City of Portland, Maine - Building or Use Permit Application

Permit No: 02-0163	Issue Date: MAR - 6 2002	CBL: 309 F008001
-----------------------	-----------------------------	---------------------

Location of Construction: 21 Aldworth St	Owner Name: Squires Kurt A & Andrea E Jts	Owner Address: 21 Aldworth St	Phone: 207-878-5562
Business Name: n/a	Contractor Name: M & M Industries	Contractor Address: 90 Pearl St. #1 So. Portland	Phone: 2073294875
Lessee/Buyer's Name: n/a	Phone: n/a	Permit Type: Additions - Dwellings	Zone: R-3
Past Use: Single Family	Proposed Use: Single Family / Add 12' x 14' breezeway and finish the 2nd story 24' x 26' garage.	Permit Fee: \$170.00	Cost of Work: \$20,500.00
Proposed Project Description: Add 12' x 14' breezeway and finsh 2nd story 24' x 26' garage.		CEO District: 1	15,750#
		FIRE DEPT: <input type="checkbox"/> Approved <input checked="" type="checkbox"/> Denied N/A	INSPECTION: Use Group: R3 Type: SB BOCA 1999 Signature: T Munson
		PEDESTRIAN ACTIVITIES DISTRICT (P.A.D.): Action: <input type="checkbox"/> Approved <input type="checkbox"/> Approved w/Conditions <input type="checkbox"/> Denied Signature: N/A Date:

SECTION A

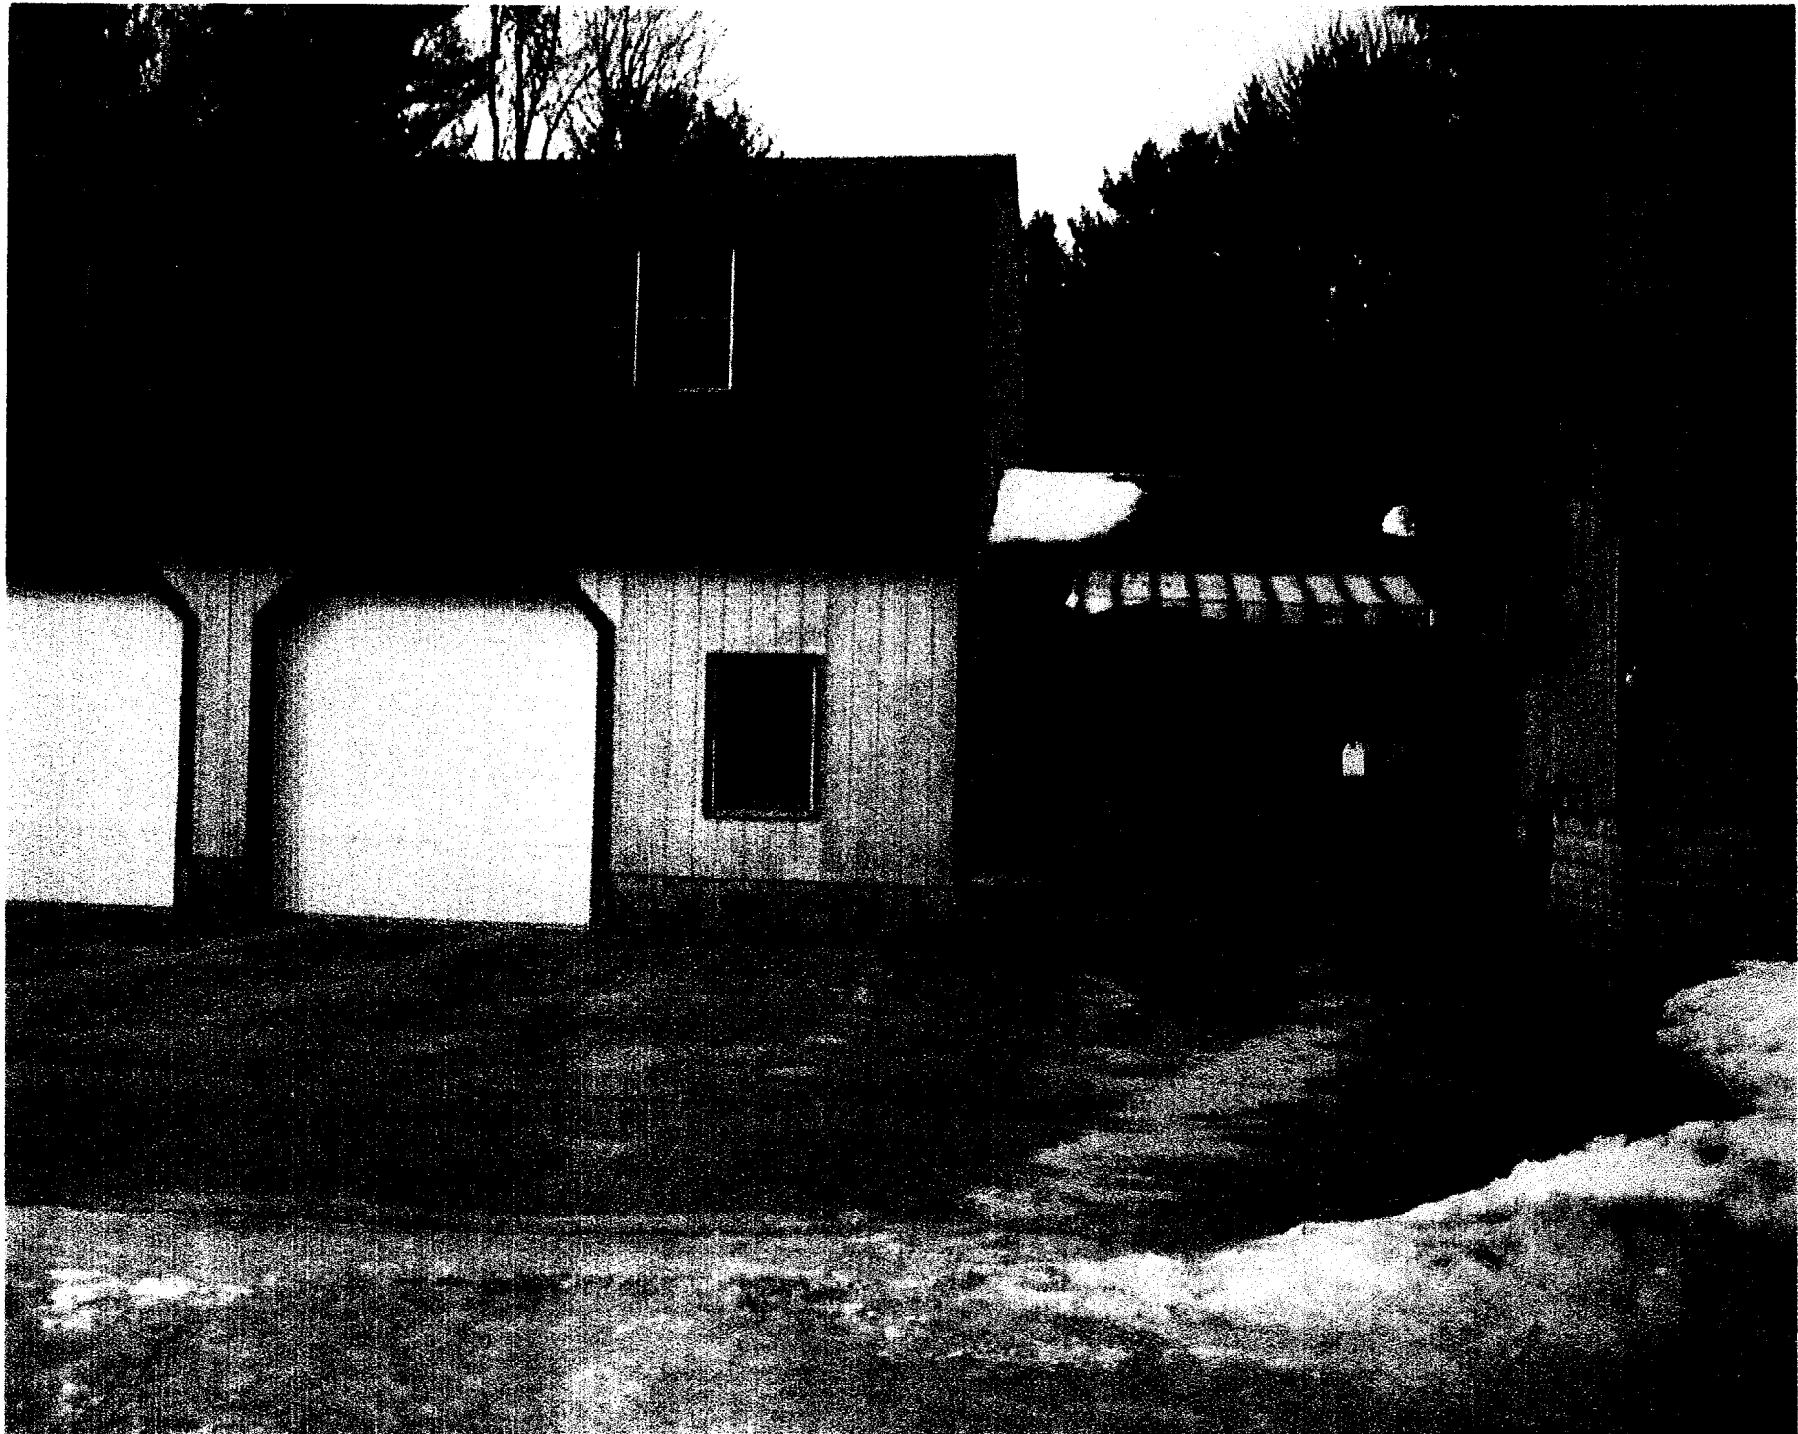
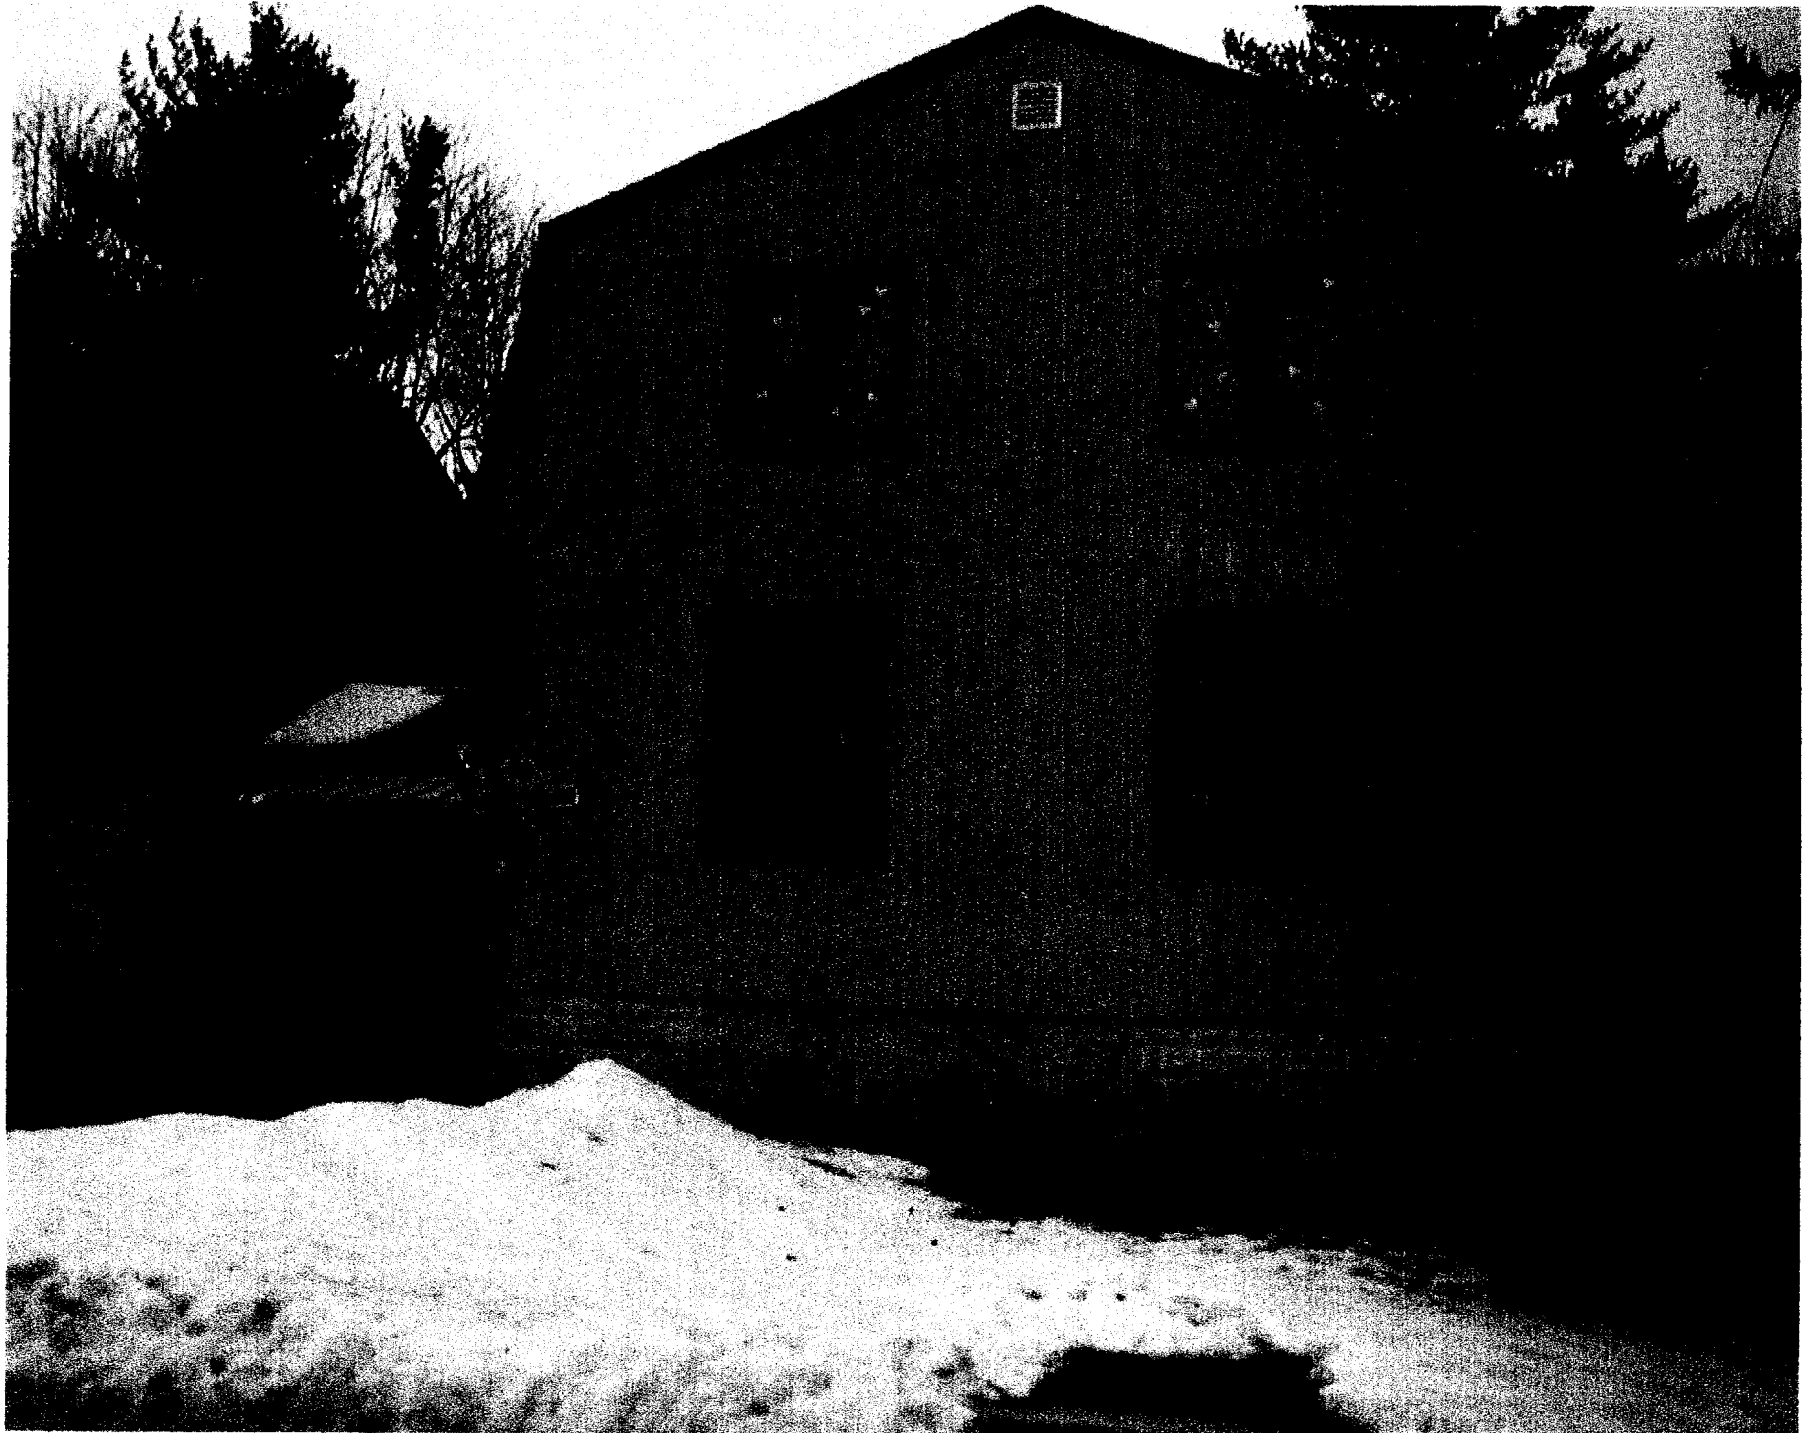
3/5/02 - Spoke to Mark @ N+M - will fire rate the entire garage ~~area~~ - area above garage is just doing sheetrock - will be a family room.
